CITY OF ALBUQUERQUE

**Re: Cliff's Amusement Park, Water Play Structure, Grading and Drainage Plan
Engineer's Stamp date 12-14-11 (F17-D031A)**

Based upon the information provided in your submittal received 12-14-11, the above referenced plan cannot be approved for Grading Permit until the following comments are addressed:

DRAWN BY: BJB  
REVIEWED BY: GLD  
DATE: 12/23/2011  
PROJECT NO.: 11-0019  
DRAWING NAME: GRADING AND DRAINAGE PLAN

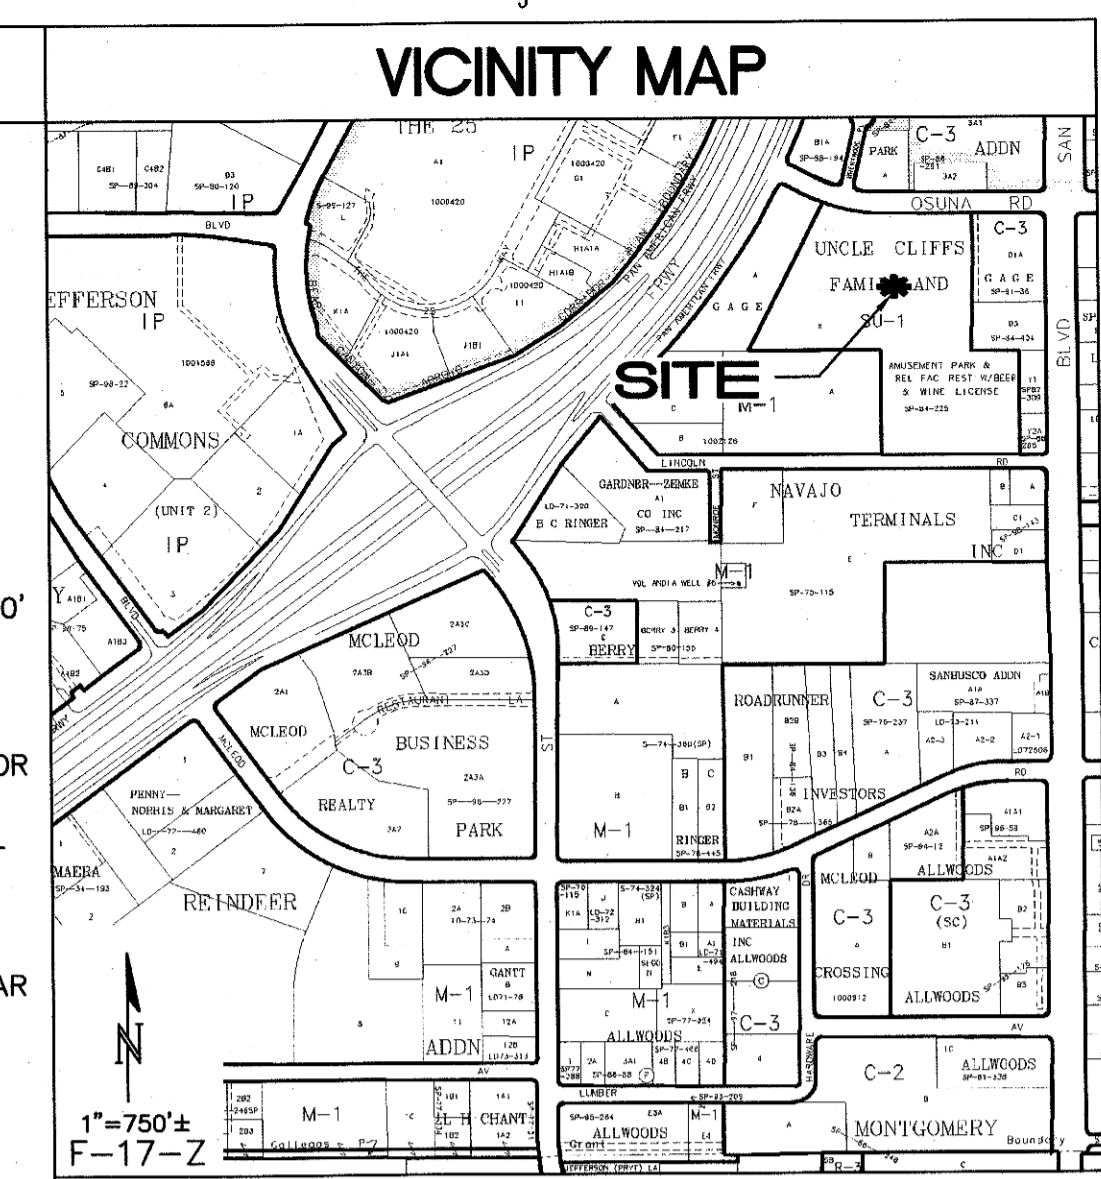
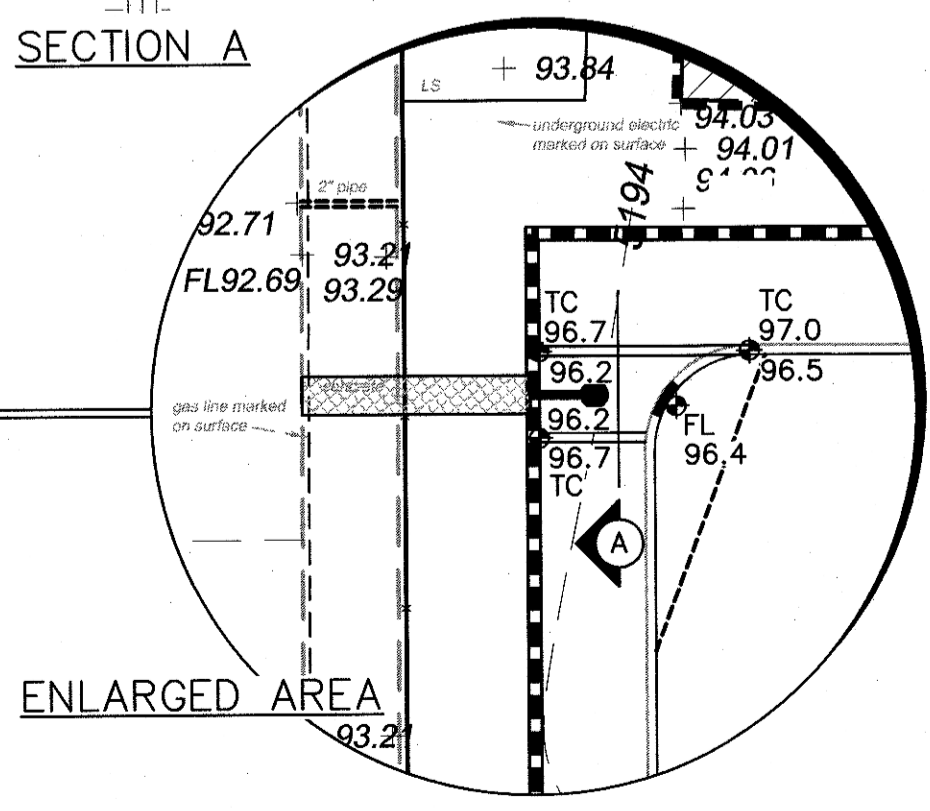
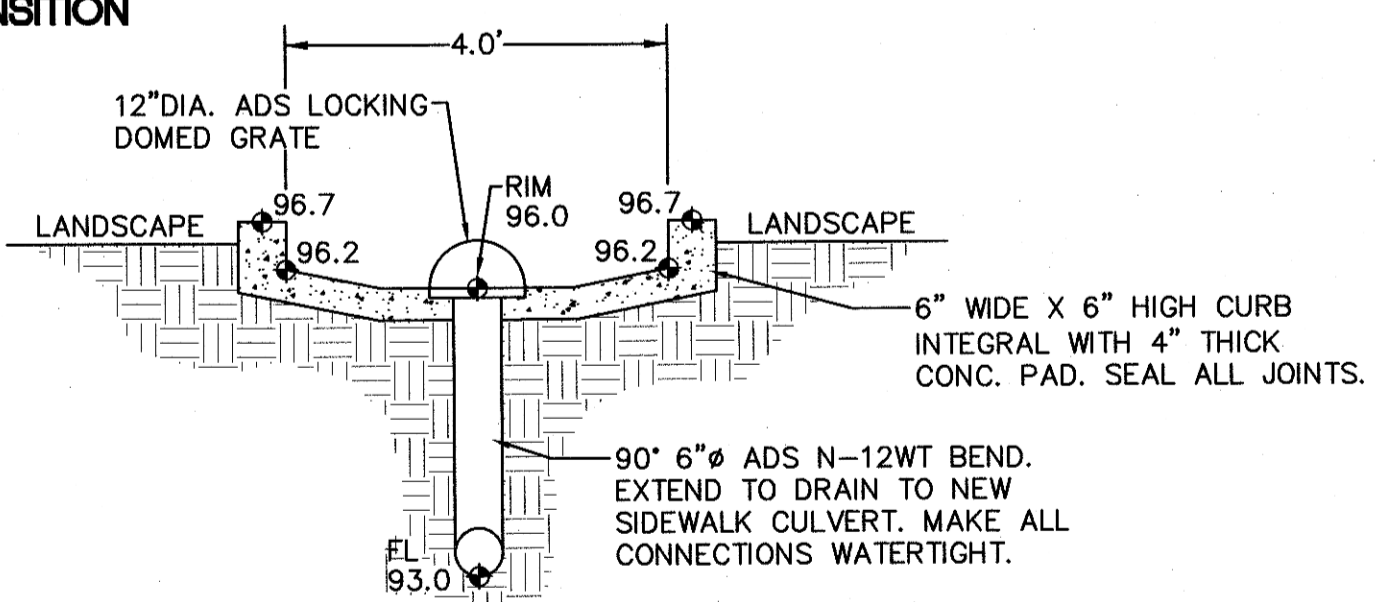
- Existing contours and spot elevations are not visible on the submitted plan.
- Please show the finished floor elevations for the existing structures.
- Provide hydraulic calculations for the proposed sidewalk culverts on the western edge of the property.
